ENVIRONMENTAL SERVICES DIVISION

19 October 2010

Re: Exhibition of Royal North Shore Hospital modification involving provision of a helipad on the roof of, and an increase in height to, the Acute Hospital building (Major Project Application 08_0172 Modification 3)

DRAWING
LEVEL 10 ROOF PLAN

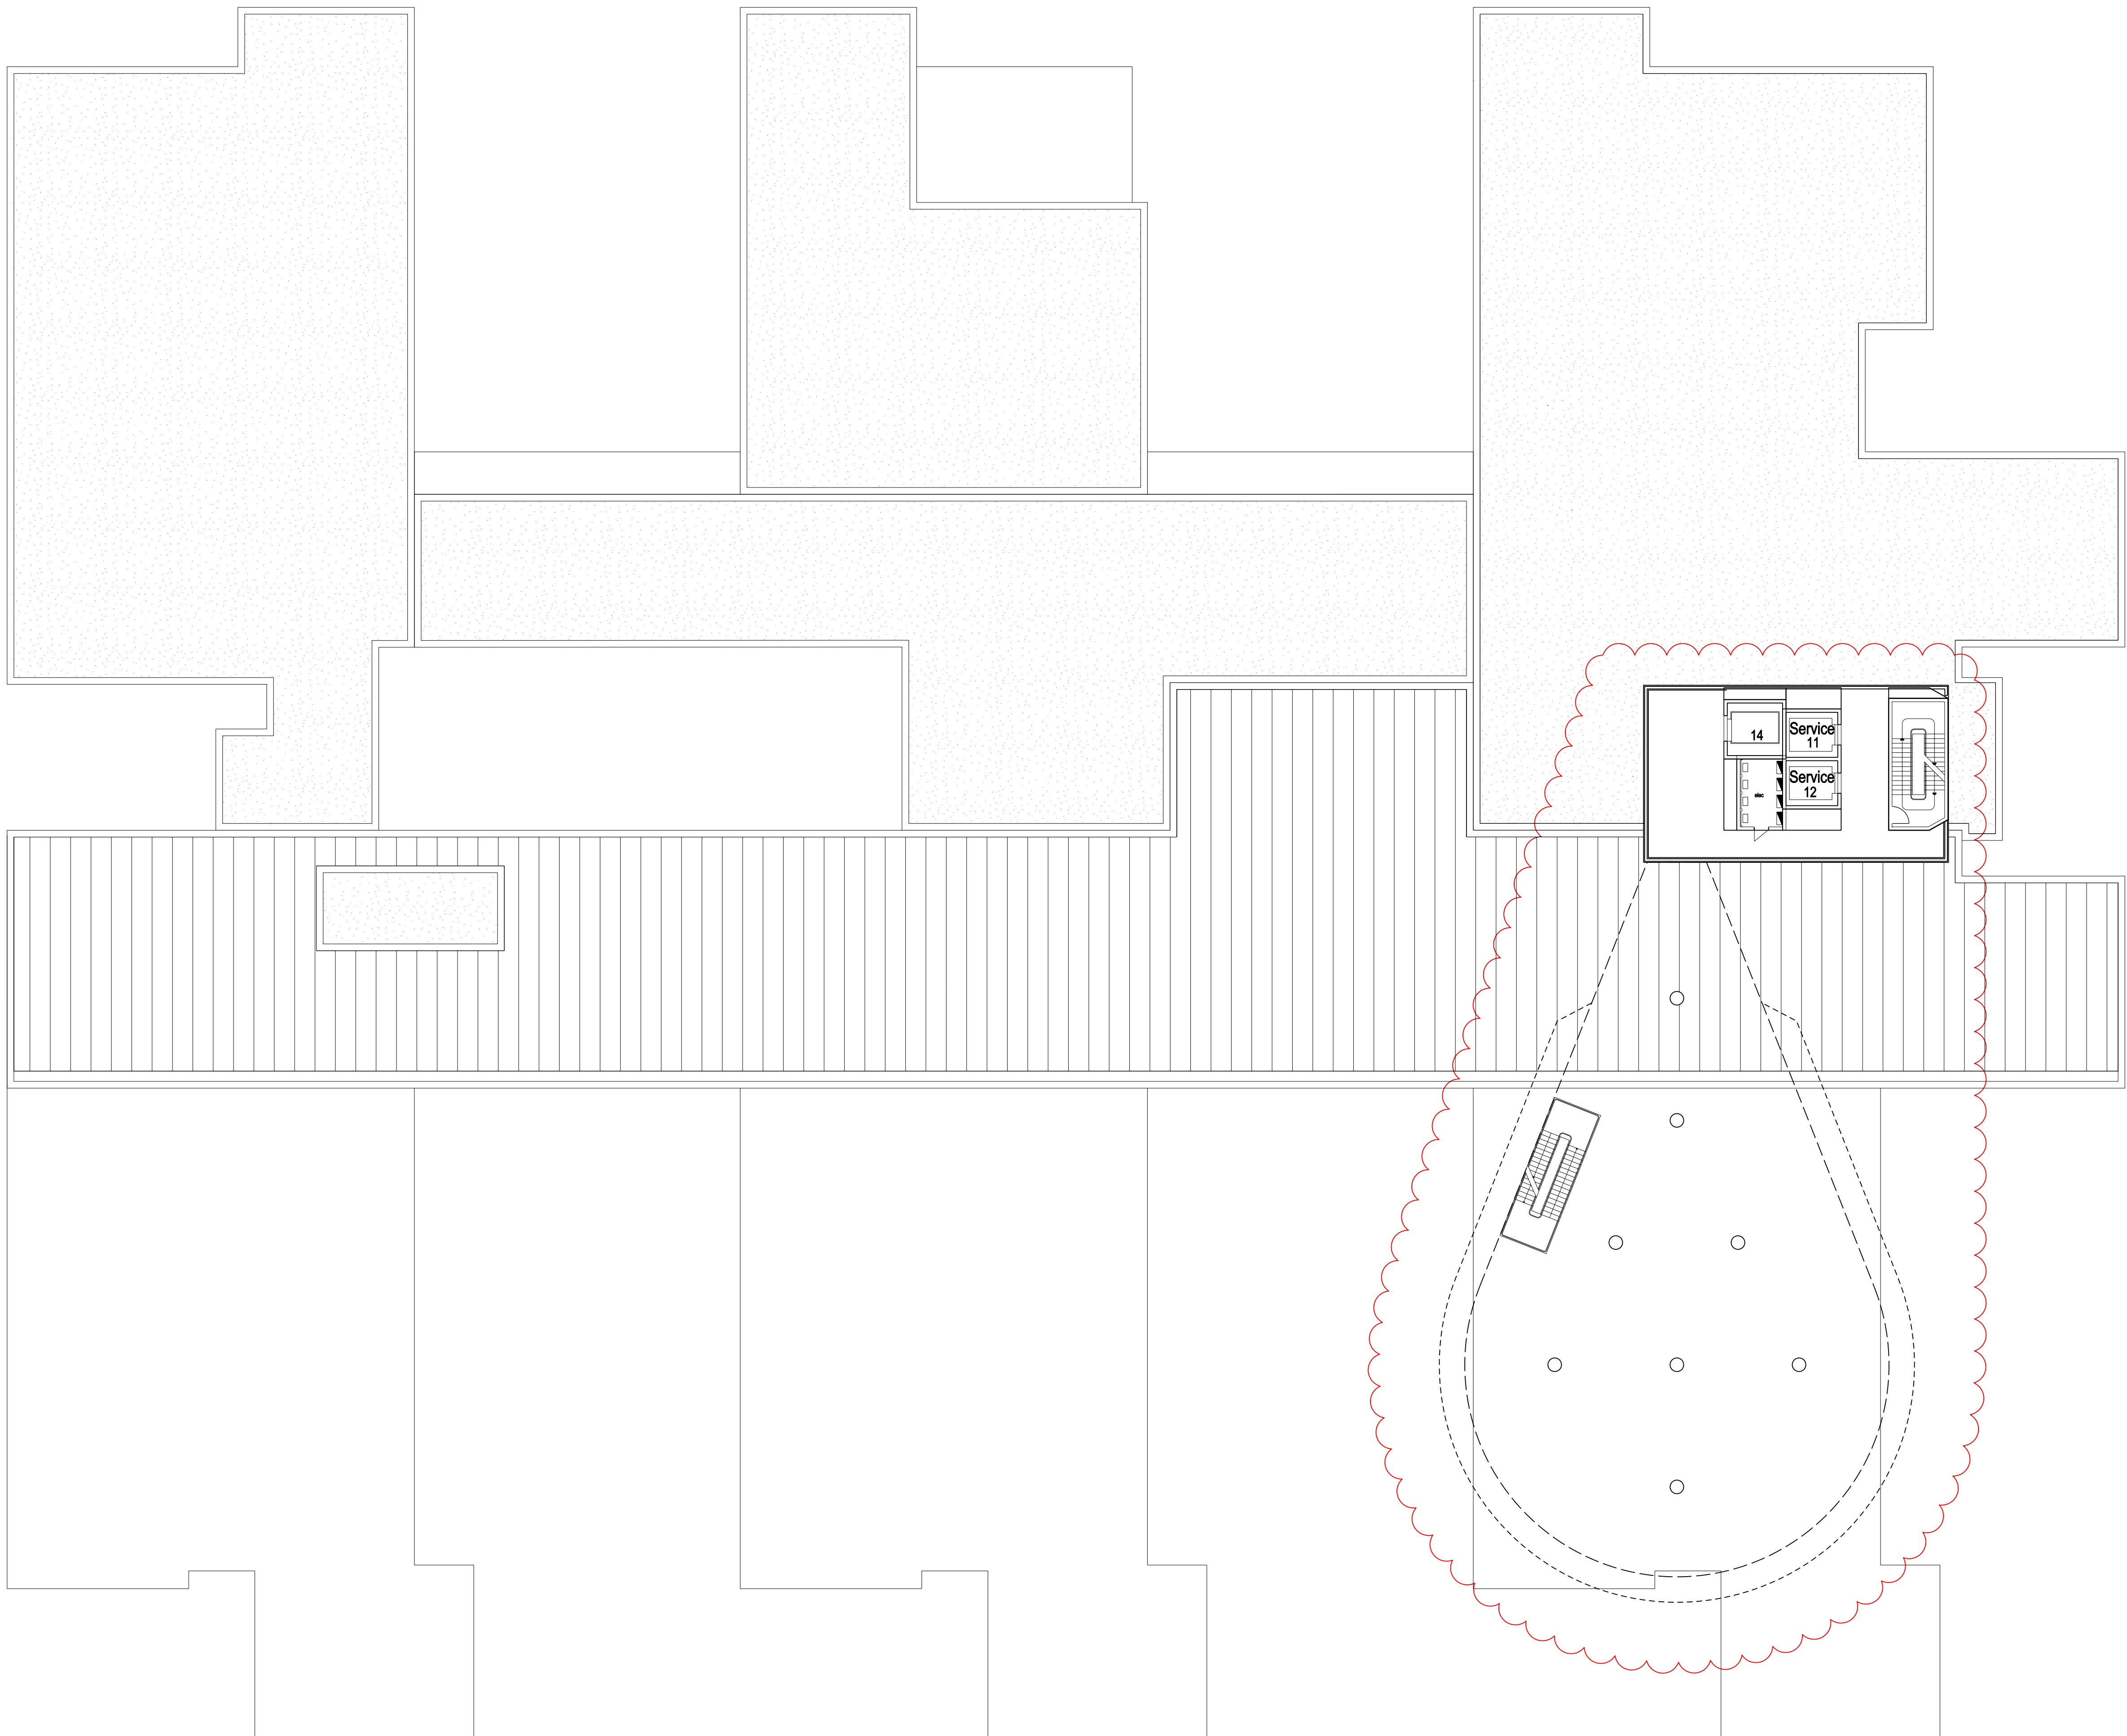
However Council is concerned and disappointed in regards the specific location on the Acute Hospital roof of the helipad. The helipad is located on an elevated platform on the south eastern side of the roof, above the main pedestrian entrance, and towards the corner of the Acute Hospital closest to Eileen Street and Herbert Street.

The proposal fails to take into account limiting amenity impacts on existing and future neighbouring residential flat buildings and mixed commercial/residential buildings as identified in the Concept Plan (as modified) for the Hospital site.

- a) The helipad be located further west and north away from its proposed location. This location appears to have been chosen because it suits the existing internal layout design of relevant sections of the Acute Hospital. Council believes that deciding the location of the helipad warrants a review of the relevant sections of the hospital, which may result in internal layout changes, in order to deliver the optimum design outcome for the hospital as well as the surrounding area.

- b) If Point a) is not adopted, then as a minimum requirement, appropriate sound attenuation barriers must be introduced to the design of the helipad on the east and south sides so that noise is minimised and the appearance of the barriers are designed so that they do not contribute to the bulk and scale of the Acute Hospital when viewed in particular from Herbert Street. In this regard, appropriate information demonstrating achievement of this change to the helipad should be submitted for Council's consideration prior to any approval.

MODIFICATIONS TO PROJECT APPROVAL

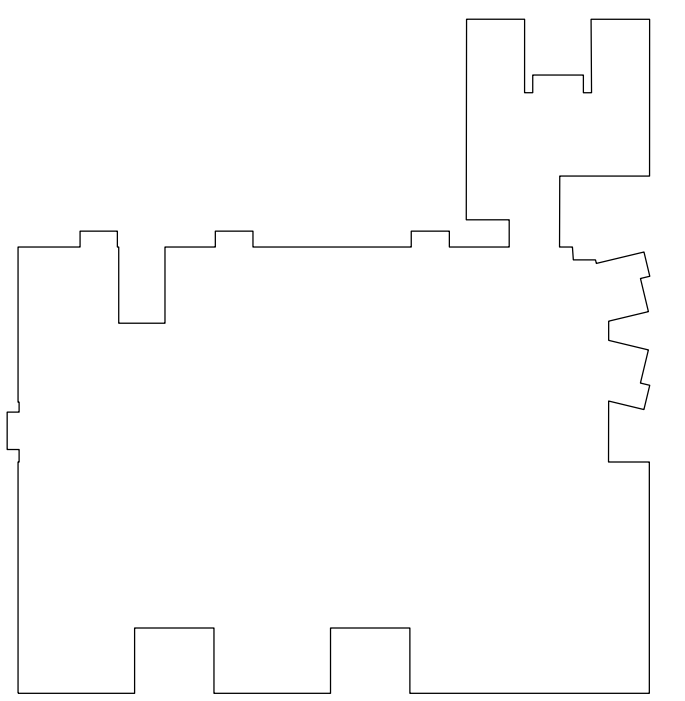
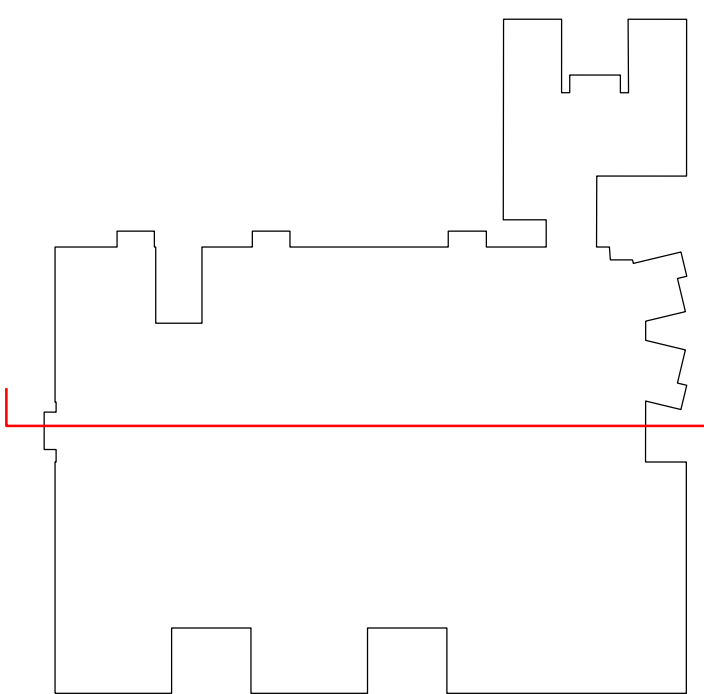
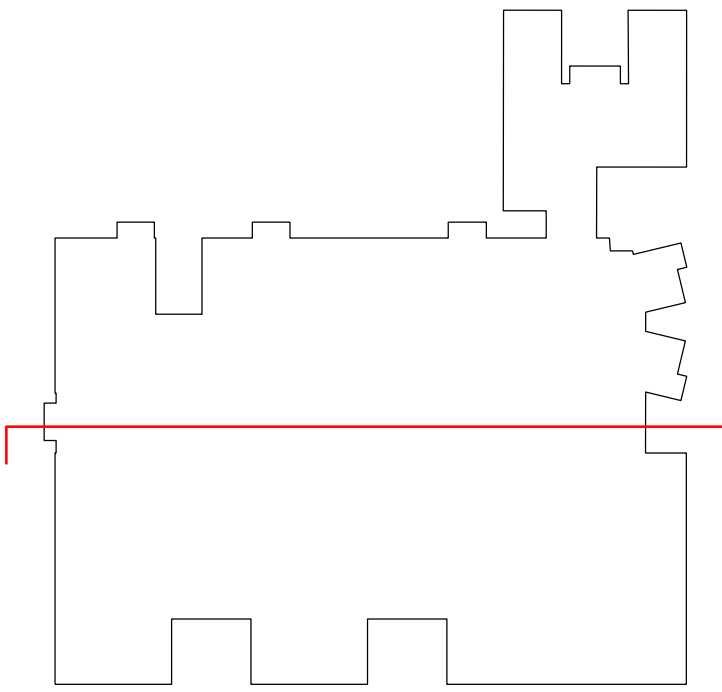
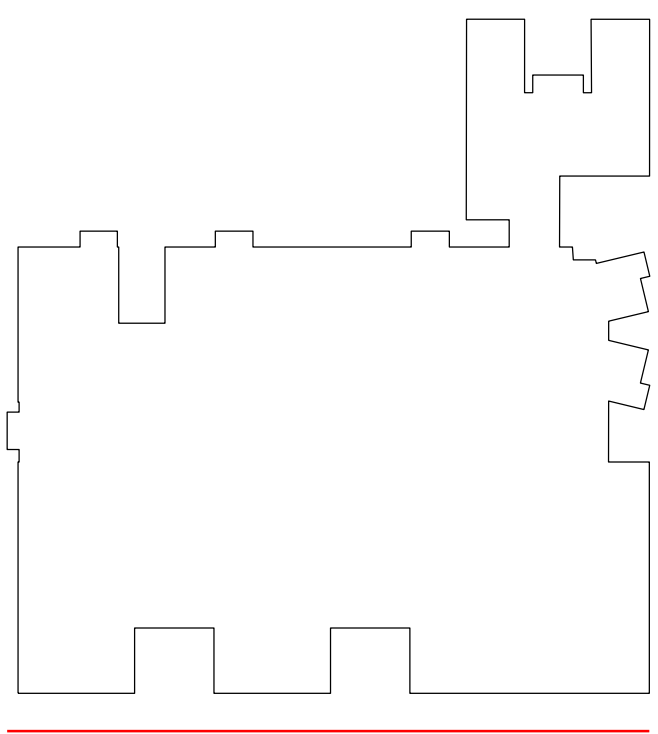
Council notes that the floor to ceiling heights of Levels 3, 4 and 5 of the Acute Hospital have been increased by 300mm each, resulting in an overall increase to the building height of 900mm.

Council raises no objection to this change.

Drawing Title  
ACUTE HOSPITAL HELIPAD APPROACH PLAN -  
LOCAL CONTEXT

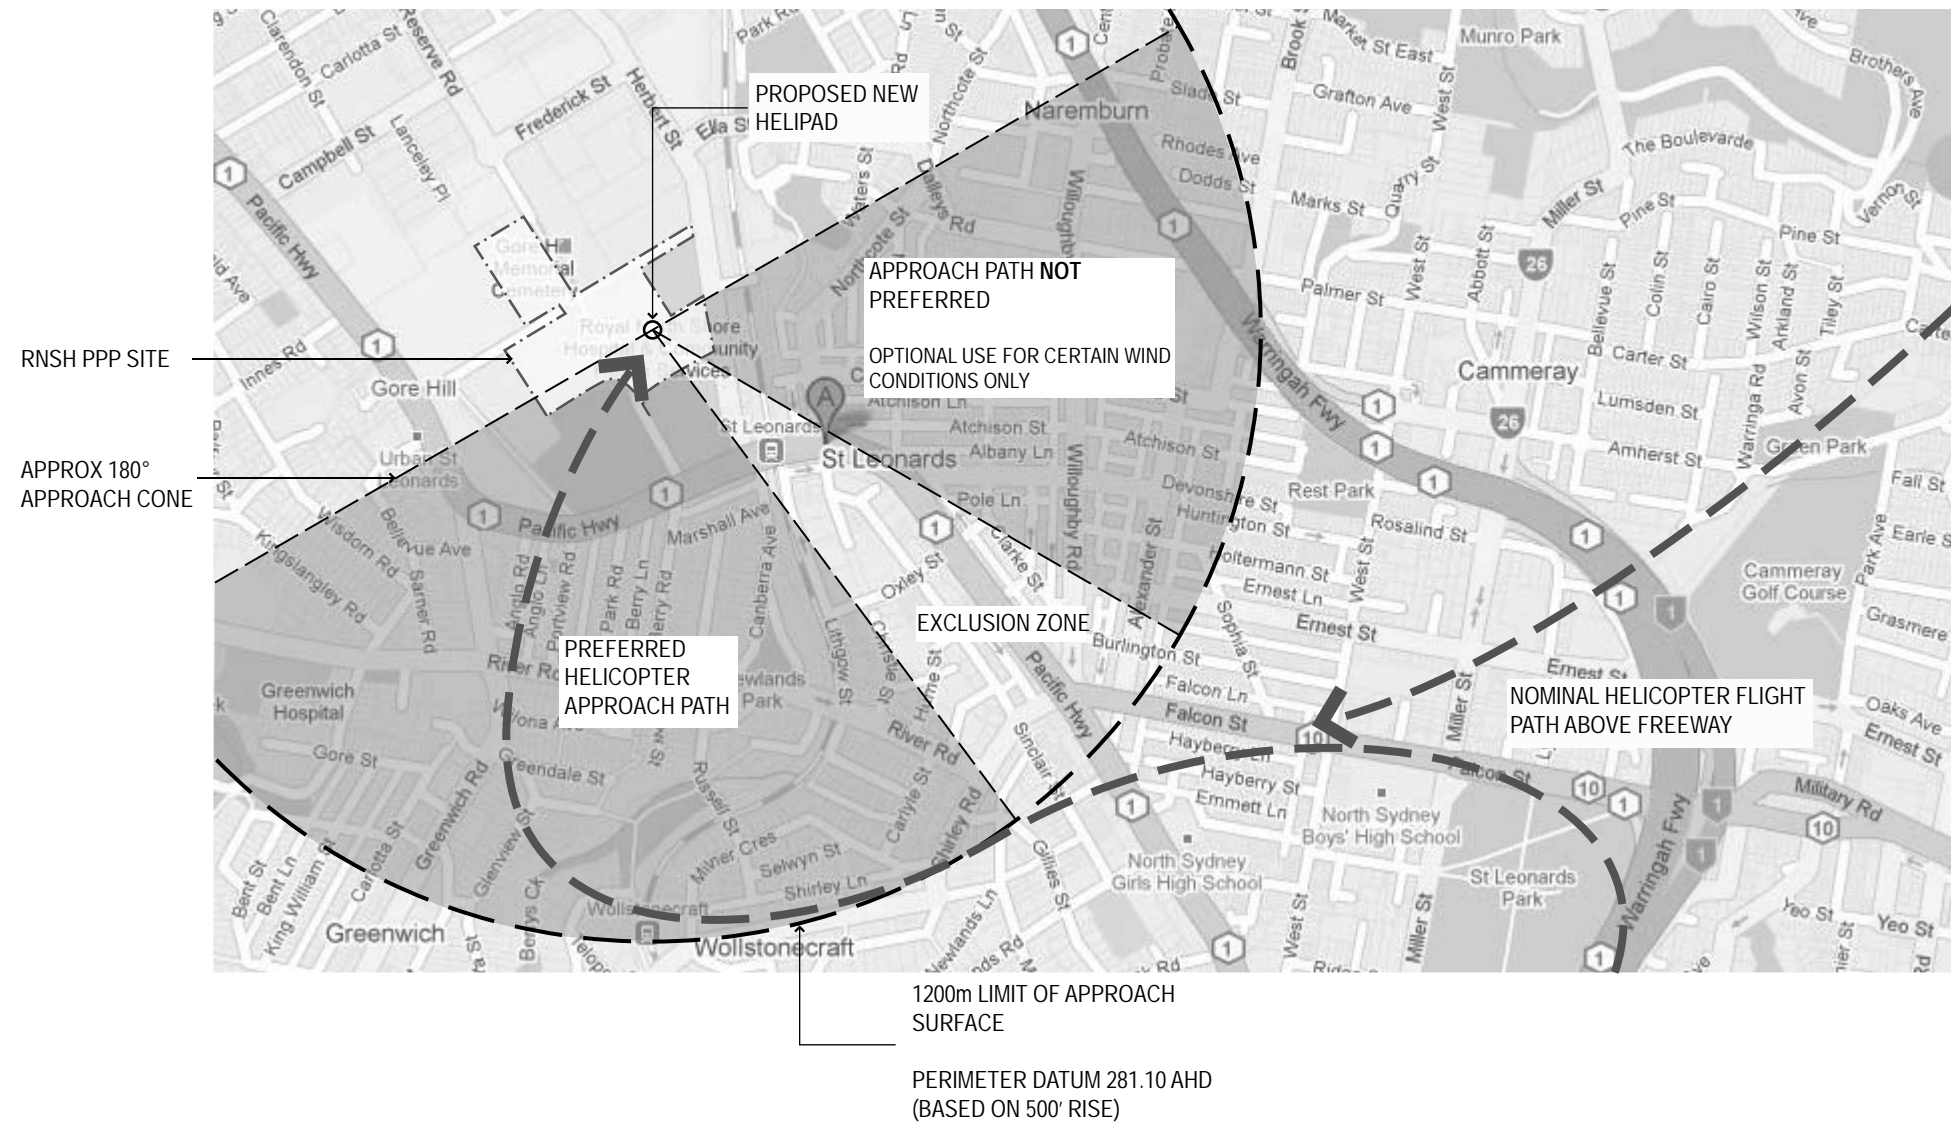
Council also supports the preferred flight path chosen, being from the south west over the Gore Hill Oval. This is the same flight path currently used for the helipad on the Douglas Building.

- c) Helicopter movements are to stay within the 'Preferred Helicopter Approach Path' as far as practically and safely possible. It is requested that movements within the 'Approach Path Not Preferred' (described as 'Optional use for certain wind conditions only' that covers a wide arc to the east of the site, over the Naremburn Conservation Area and a number of high rise residential flat buildings along Herbert Street), be kept to a absolute minimum. In this regard Council requests that a condition be placed on any approval requiring the flight path to comply with the information submitted with this modification.
